APPLICANT'S RESPONSE TO INTERESTED PARTIES' DEADLINE 4 SUBMISSIONS: 9.27

Cory Decarbonisation Project

PINS Reference: EN010128

March 2025

Client: Cory Environmental Holdings Limited

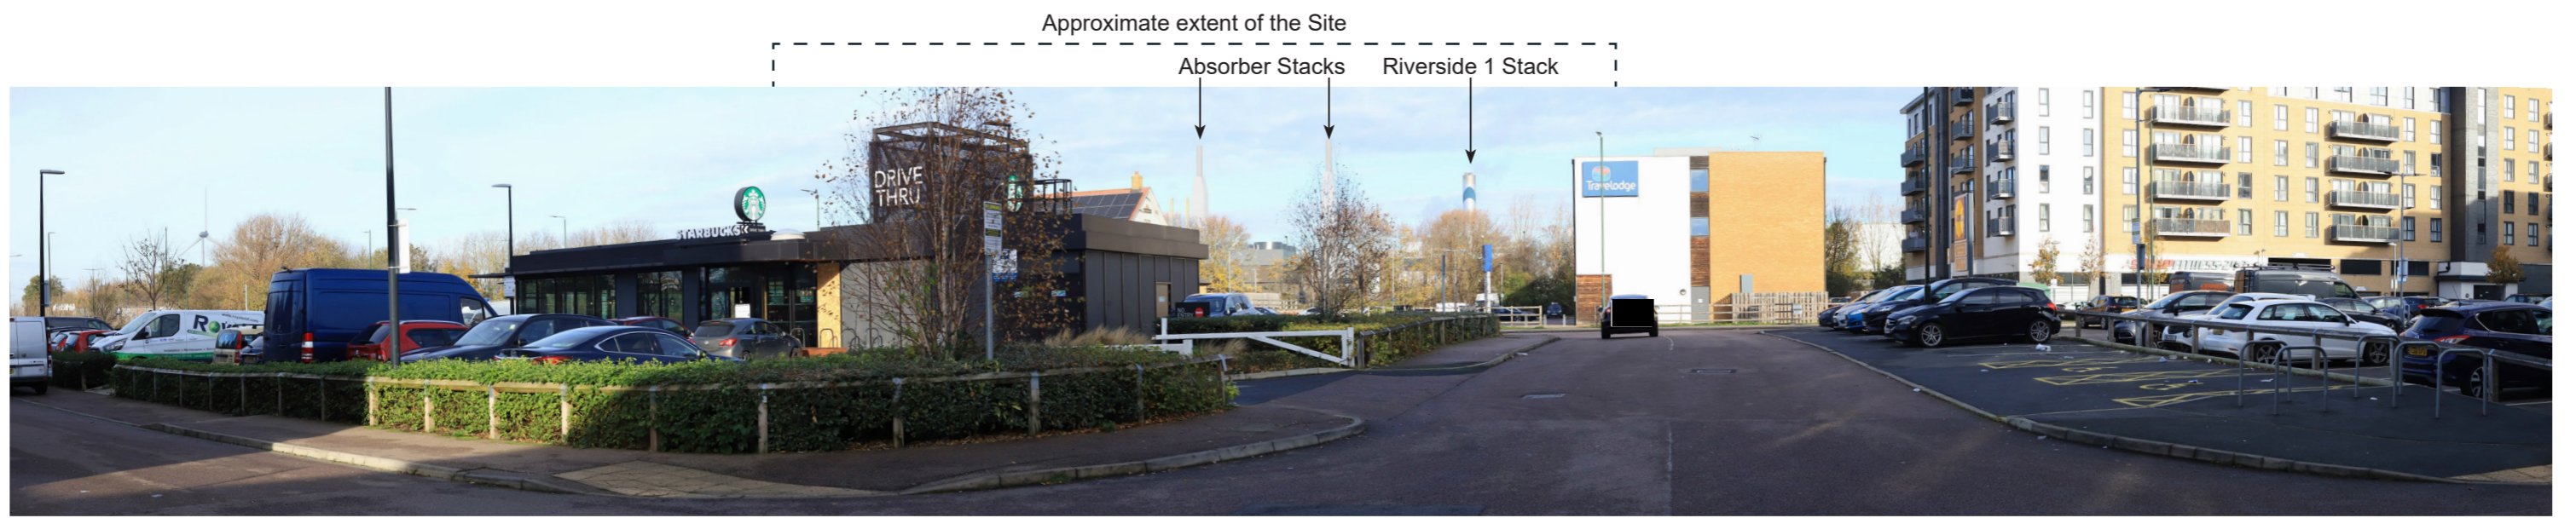
Design		
2.6.3	<p><u>Visual impact - photomontages</u></p> <p>8. As raised during the Accompanied Site Visit, we are concerned that the Photomontages do not depict the full visual impact on Crossness Nature Reserve. There is no view showing the full north-south stretch of the Proposed Scheme from Crossness Nature Reserve. 'Sequential View 1' is largely obscured by Riverside 2. 'View 1' shows the Proposed Scheme from FP2 looking north, where the impact is less severe: REP1 and REP2 are already in the sightline, and you do not see the crosssection of the full north-south length of the Proposed Scheme.</p> <p>9. We request that the Applicant provide an additional view from the entrance to the Member's Area (at the end of the access road and along the north-south path along the western edge of the main Crossness Nature Reserve area), so that the visual impact of the full north-south length of the Proposed Scheme can be assessed. This would also give a close representation of the view from the bird hide, which is particularly sensitive to visual impact.</p>	<p>Please see the Applicant's response to the ExA's question 2.18.1, also submitted at Deadline 5.</p>
